DRB Application No.: 10DRB-70044 Project # 1008190  
Project Name: ZIMMERMAN ADDITION  
Agent: ADVANCED ENGINEERING Phone No.:

9.  **Project# 1008190**  
10DRB-70044 MINOR - PRELIMINARY/  
FINAL PLAT APPROVAL
- ADVANCED ENGR. AND CONSULT. request(s) the above action(s) for all or a portion of Lot(s) A & B, Block(s) 3, **ZIMMERMAN ADDITION** zoned C-2, located on 4712 CENTRAL AVE SW BETWEEN 47TH ST SW AND 48TH ST SW containing approximately 0.8464 acre(s). (K-12) **THE PRELIMINARY/FINAL PLAT WAS APPROVED WITH FINAL SIGN OFF DELEGATED TO TRANSPORTATION FOR SIDEWALK RIGHT-OF-WAY OR PUBLIC EASEMENT.**

PLAT OF  
**LOT A-1, BLOCK 3**  
**ZIMMERMAN ADDITION**  
 CITY OF ALBUQUERQUE, BERNALILLO COUNTY, NEW MEXICO  
 JANUARY, 2010

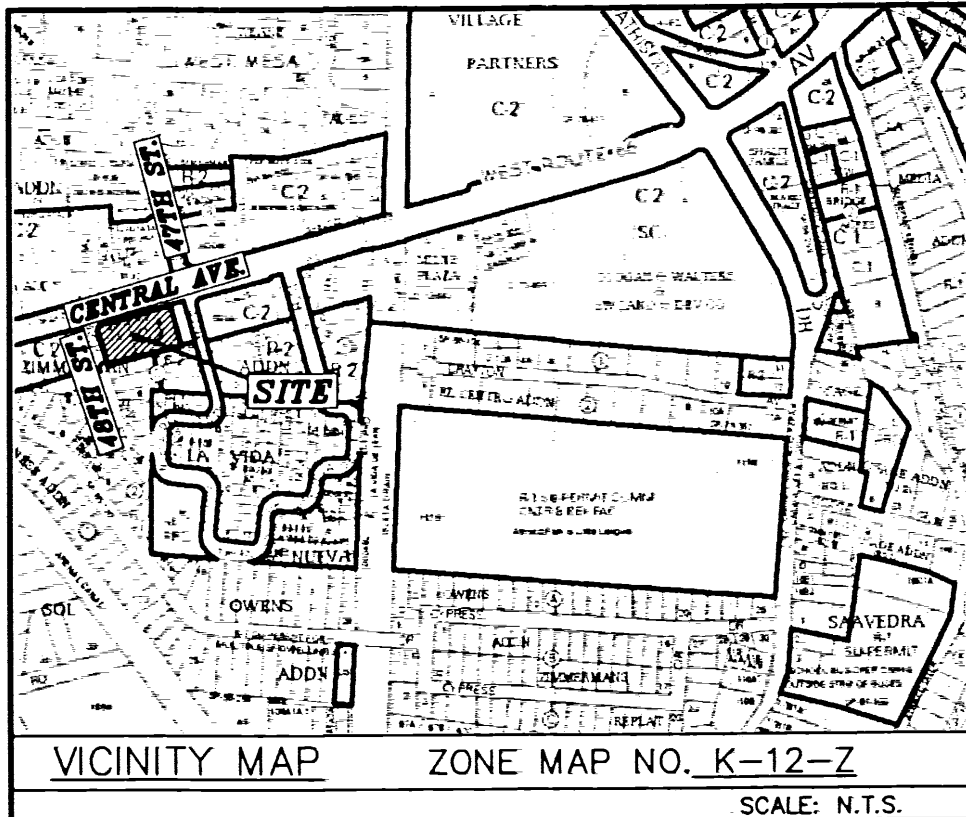
TRANSPORTATION: - sidewalk R.O.W or Public  
Easement

PLANNING (Last to sign): Add Solar Note 14-14-4-7
